Five Estuaries Offshore Wind Farm Case
Team
Planning Inspectorate
FiveEstuaries@planninginspectorate.gov.uk
(By Email only)

MMO Reference: DCO/2019/00008
Planning Inspectorate Reference: EN010115
Identification Number: 20049306

Planning Act 2008, Five Estuaries Offshore Wind Farm Ltd, Proposed Five Estuaries Offshore Wind Farm Order

Deadline 4 Submission

**Figure 4 Sediment dispersal during jetting (IMCA Code of Practice for Offshore Cable Laying in the Renewable Energy Industry M264 Rev. 0.1 – November 2023)**

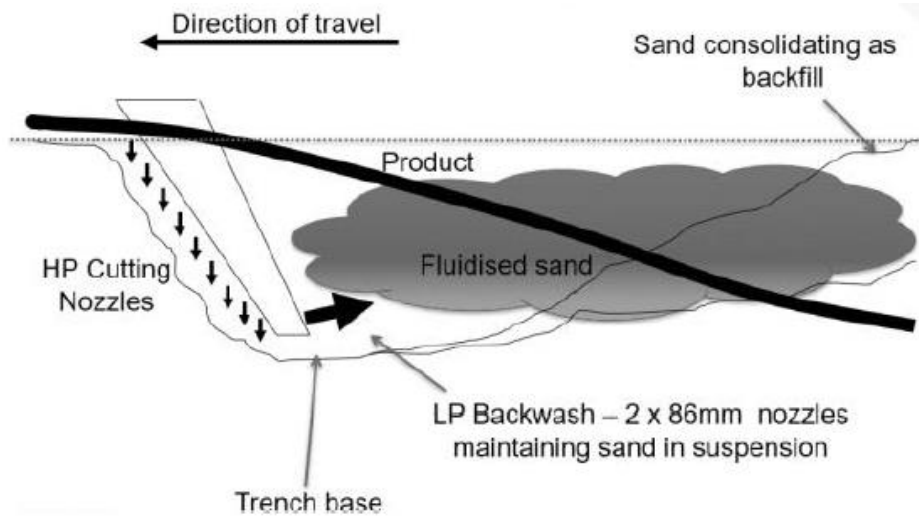
- 2.4.4. In relation to fluidized material, the Applicant states the MDS for trial trenching (see Table 1.6 in REP2-027) is “...estimated with a 50% assumption, regarding the amount of sediment disturbed. This value is used because during the trenching not 100% of the material is dispersed into the water column. An example of this for jetting is shown in the sketch in Figure 4. Some of the sand is fluidized into the water column and may disperse, however some backfills over the cable. The values in the table for the maximum volume are calculated from a typical average burial depth of 1.75 m, the maximum value of 3.5 m is a maximum indicative value. The actual burial depth will be below the average, hence this value has been used to assess the impact of sediment dispersal on sensitive receptors in the marine environment.”

The MMO would like to highlight that the Figure number within the paragraph above is missing within the document.

- 2.4.5. The MMO notes that although the Applicant states this assumption is used as the trenching will not disperse 100% of the material into the water column, it is not clear why a value of 50% has been applied. The amount the material disperses is likely to vary based on sediment composition - for example silt will disperse to a greater degree than sand or gravel. The use of any such value should be evidence-based and appropriately justified. The MMO asks the Applicant to clarify what this value is based on.
